From: Andrew Wood
Sent: 09 December 2019 11:34
To: Planning Scanning
Subject: FW: WA/7/19/RES - Lanes End, West Walberton Lane - Extension of time request

WA/7/19/RES - Lanes End, West Walberton Lane - Additional information request

DATE:	DWG. NO.
APRIL 2019	19-001
SCALE @ A1:	PL06
1:100	
REV:	A

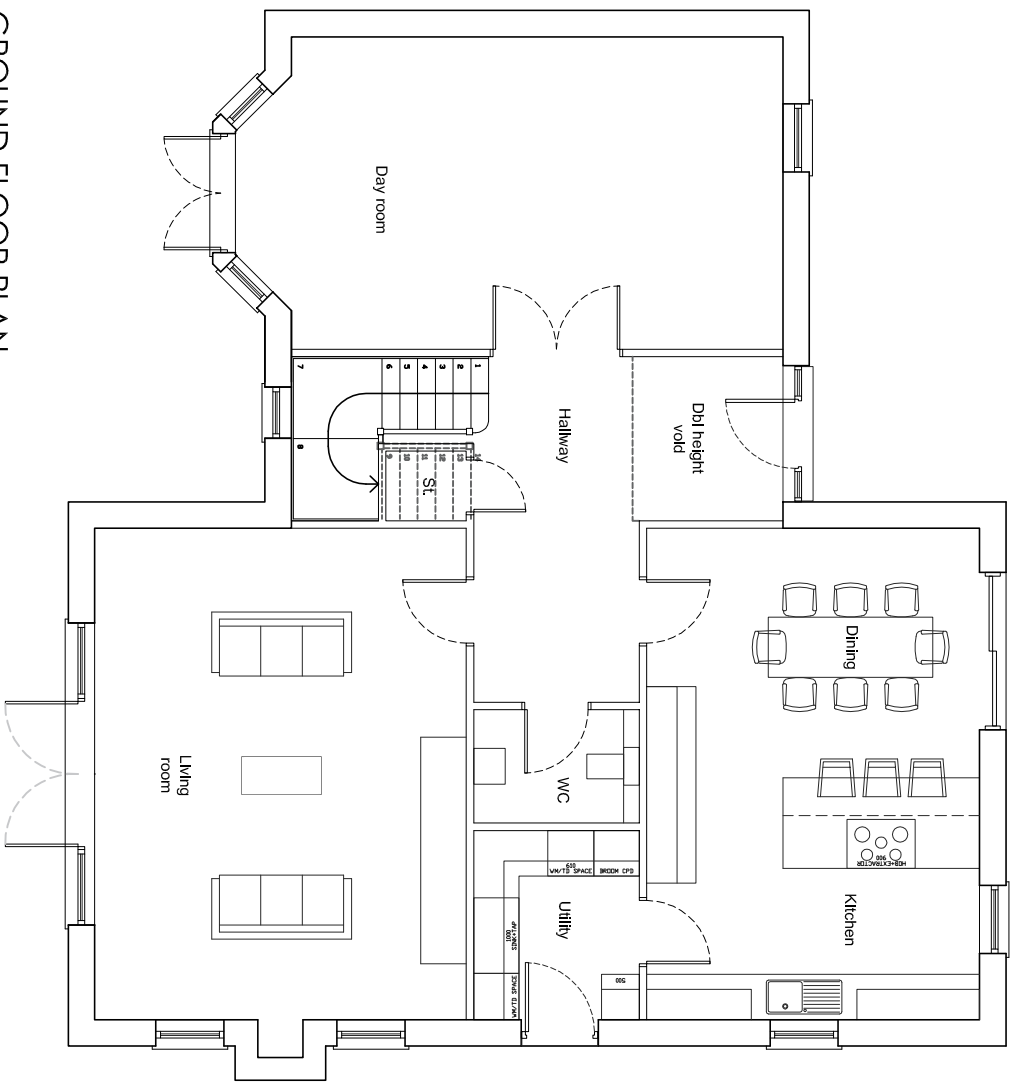
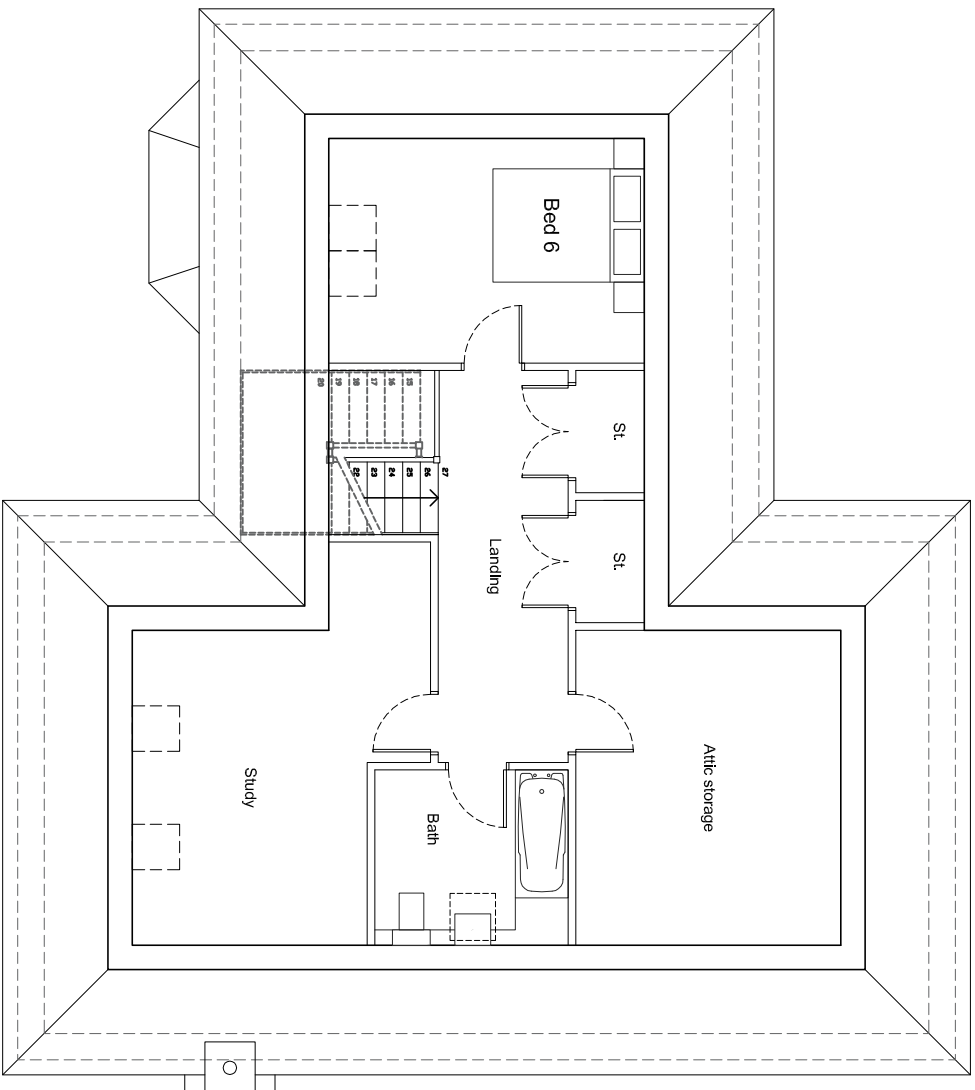
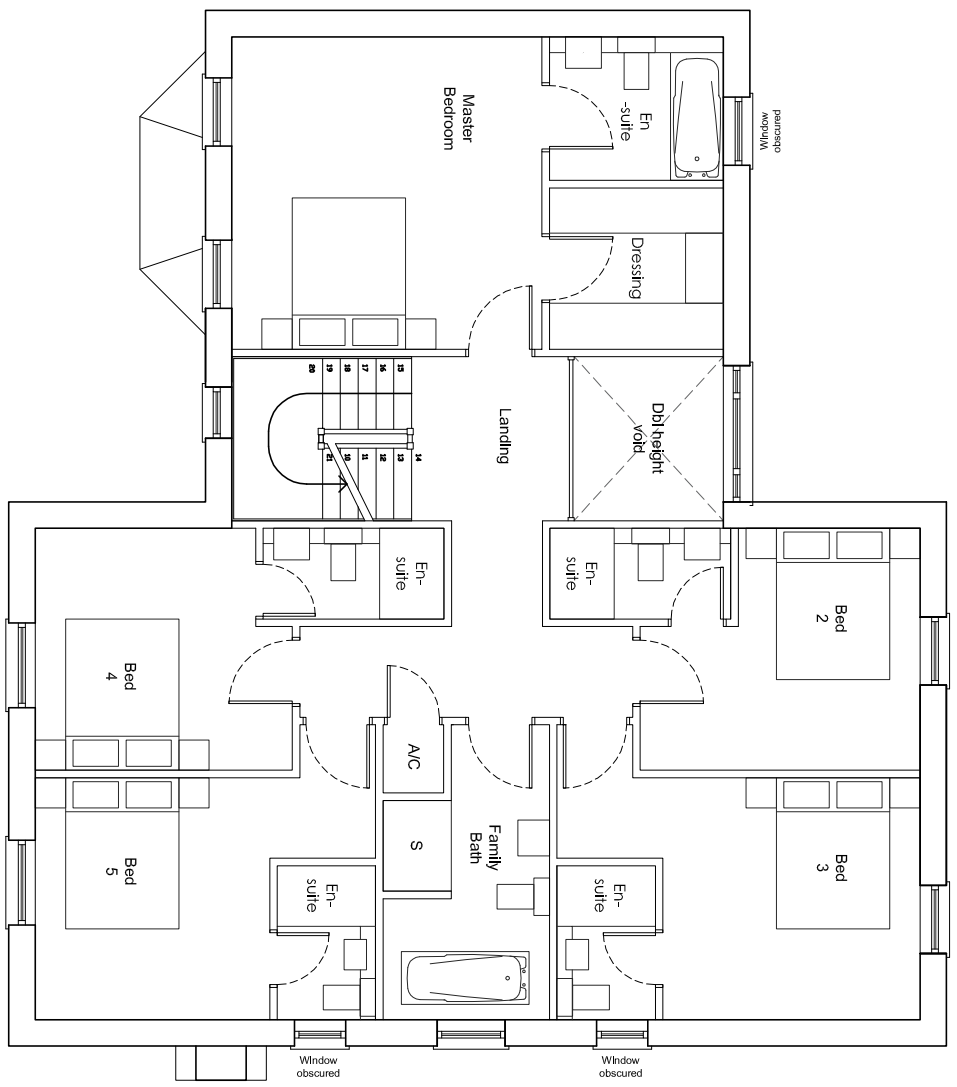
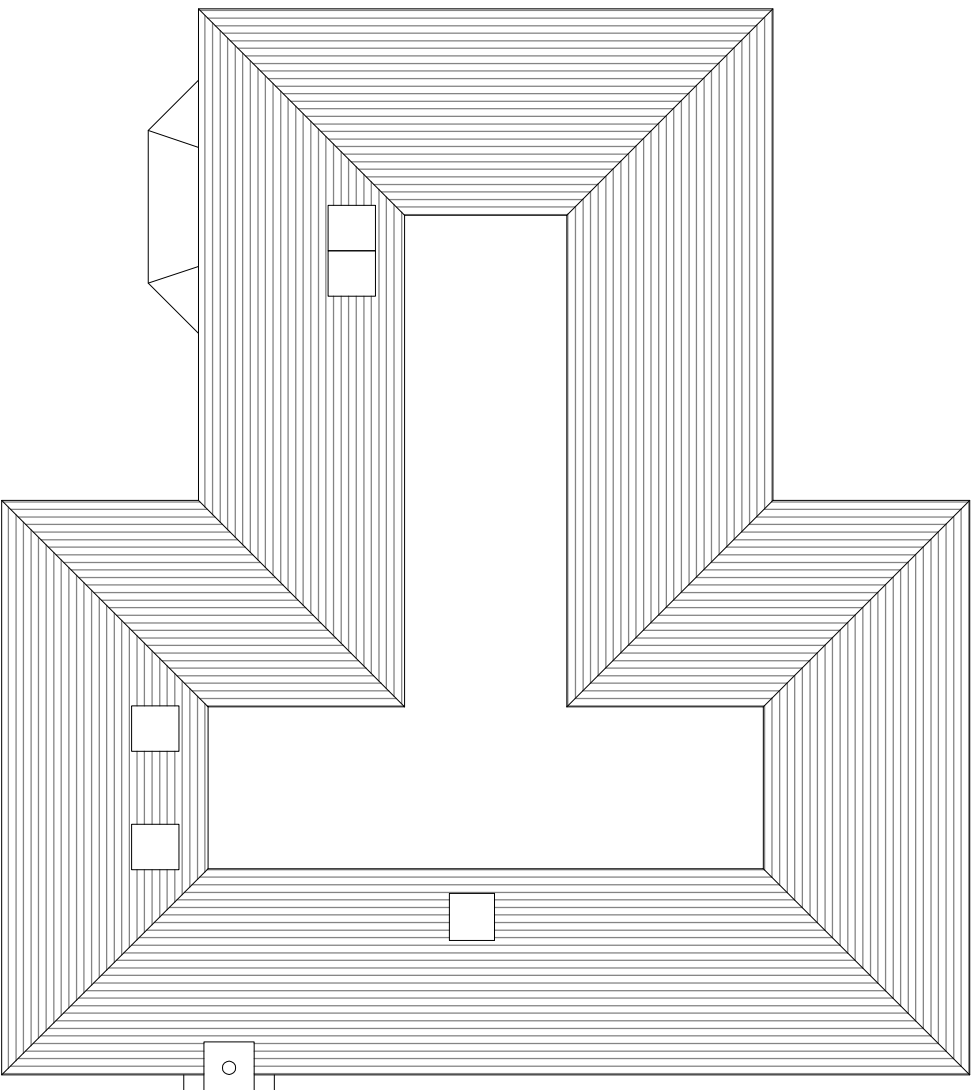
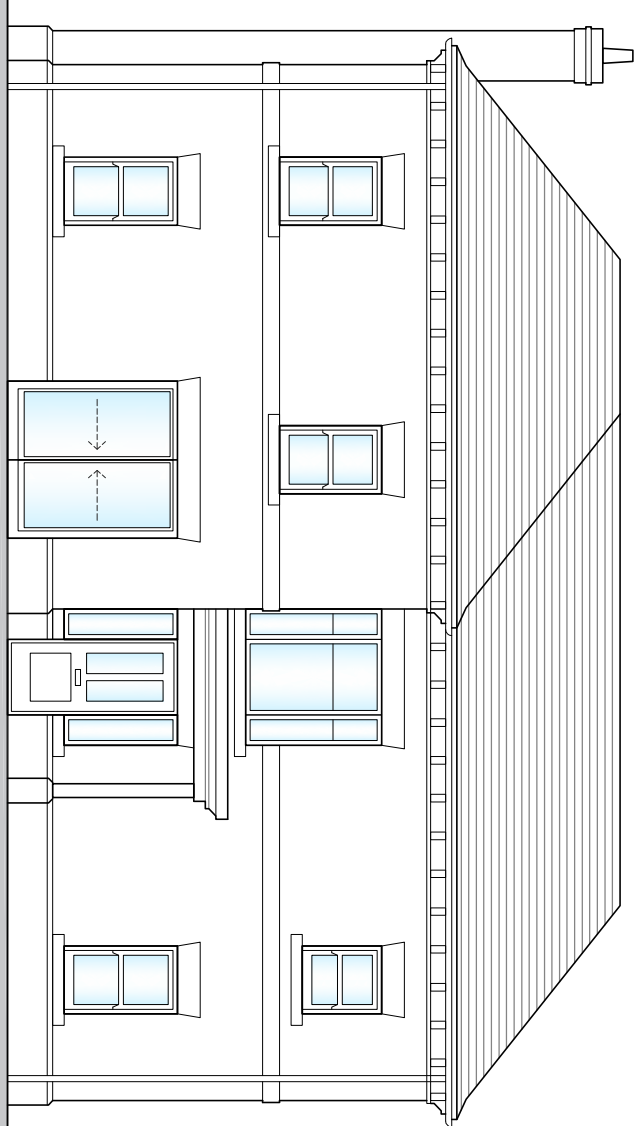
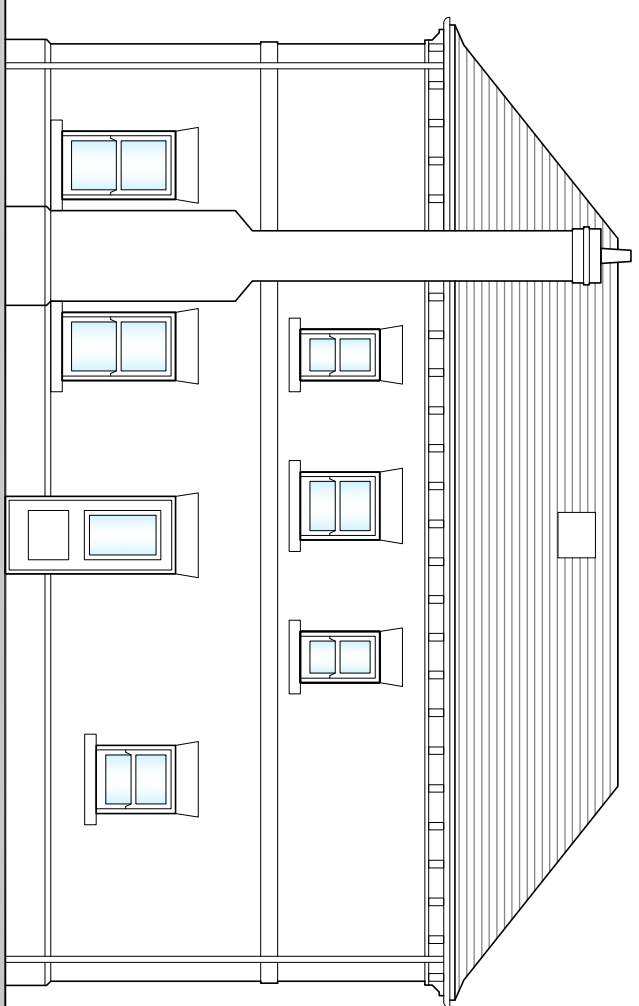
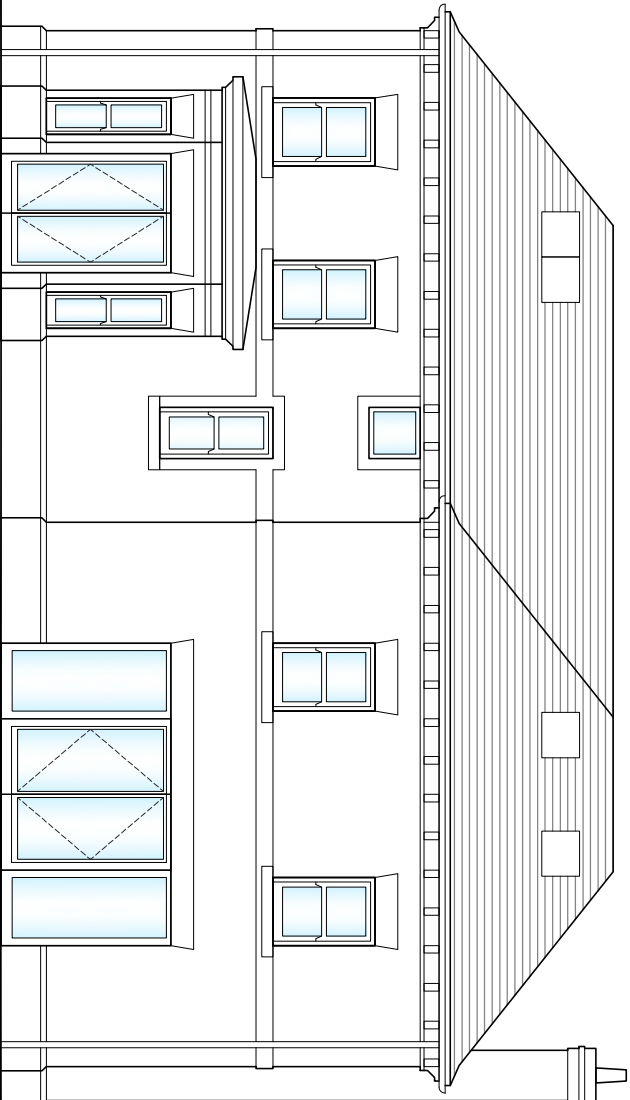
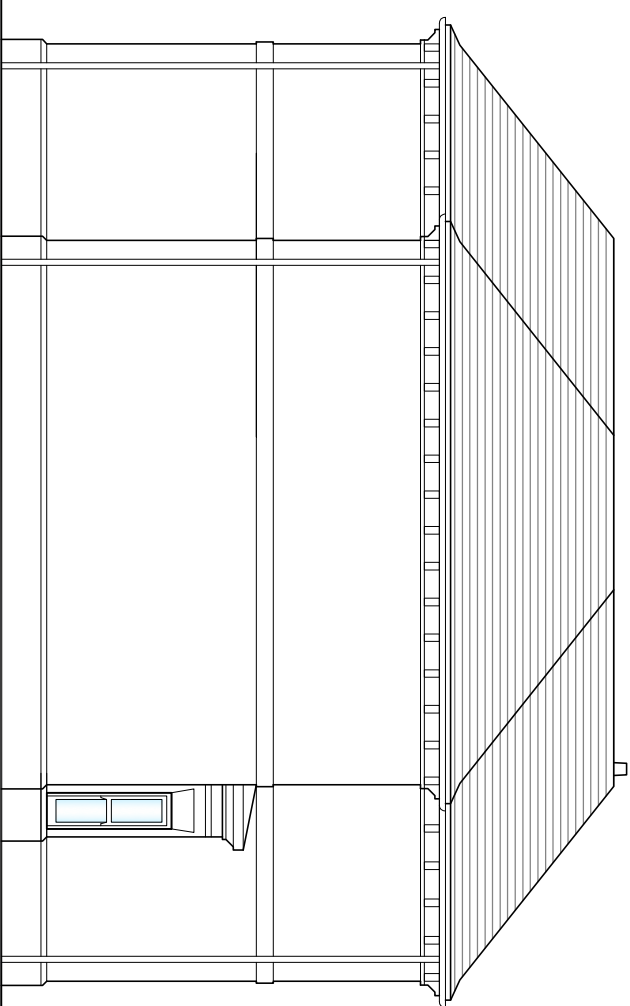
the issue with the rooms in the roof is that the appearance of the dwellings will be of a town house which is simply not appropriate in this location. I would strongly advise you to remove this element from the scheme. To avoid the risk of the development being viewed as 'out of character' in the area and contrary to policy D DM1 of the Arun Local Plan. I have discussed the matter with my line management team and everyone is of the same view in this case.

1. Amend the layout to ensure that a minimum of 9 metres exists on from blank gable end (or obscure glazed windows non opening below 1.7 metres in height) of nearest proposed house to gable end of 'Woodlands' which currently incorporates sole habitable room windows.
2. Remove second storey of houses/rooms in roof. 3 storey townhouses would not be acceptable in this location

2, we fail to see the merit in removing the room in the roof, this would have no impact on the height of the buildings and would result in empty lift spaces which would not allow for good use of space as per the NPPF. You will note from drawing 19-001-PL-03 all the dormers on houses 3-6 are in the south and therefore can not be seen from the front or any point outside the properties. Currently prosperities one and two have the dormers on the north but I would be happy to move these to the south so these are the same and none can be seen from Arundel road. I also would like to mention the design of white cottage next door that will have dormers in the roof and Richmond house which has velum windows in the roof. As previously mentioned the new ridge heights will be lower than the current house at Lanes end this can be seen in the scale drawings provided. If you could let me know if this is acceptable as if possible to avoid I would prefer not to have to appeal the reserved matters for this small item.
